KITITITAS COUNTY COMMUNITY DEVELOPMENT SERVICES

RE: Transmittal of Comments – A. Marchel Short Plat (SP-13-00004)

TO: Jeff Watson, Community Development Services
FROM: Christina Wollman, Planner II CW
DATE: April 16, 2013
SUBJECT: A. Marchel Short Plat SP-13-00004

A. MARCHEL SHORT PLAT
 A PORTION OF THE WEST 1/2 OF SECTION 14,
 TOWNSHIP 17 NORTH, RANGE 20 EAST, W.M.,
 KITTITAS COUNTY, WASHINGTON

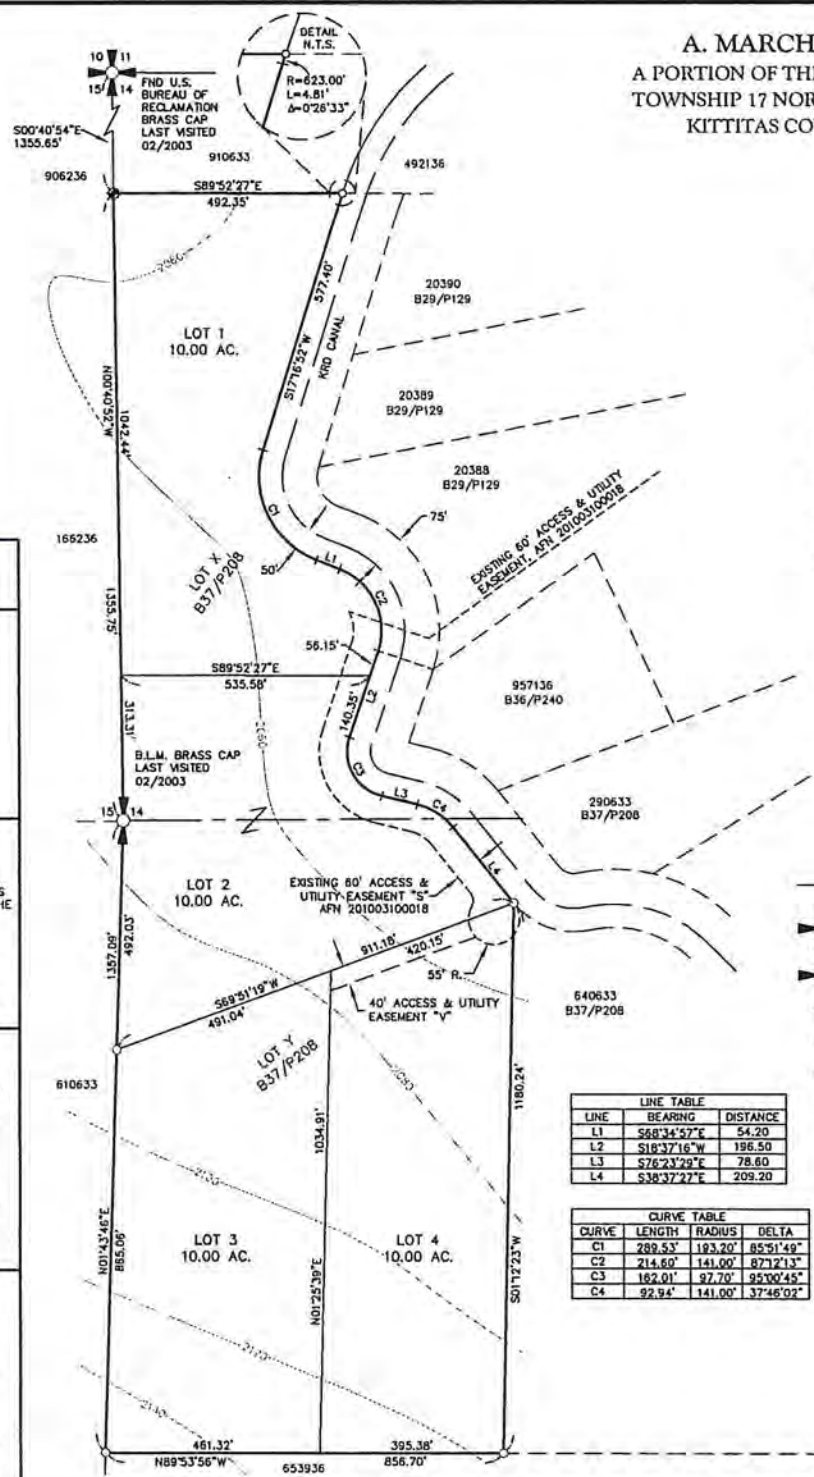
3. Bridge: The bridge over the KRD canal shall meet all requirements of the International Fire Code, Kittitas County Road Standards 12.07, the building code, and the KRD. A KRD permit is required prior to construction. New bridges shall be the same width of the roadway and be rated to 75,000 lbs. Inspection of bridges shall be conducted by a Washington State licensed professional engineer familiar with bridge design, construction and load ratings. The inspection shall be submitted to Public Works with the road certification and prior to the issuance of a building permit.

- The access to the property appears to cross over the KRD canal. If a bridge is currently existing in place, it is not required to be brought up to County Code, however if a new bridge needs to be built, or any structural work needs to be done to an existing bridge, it must be approved through a permit from the Fire Marshal's Office.
- All future development must comply with the International Fire Code.
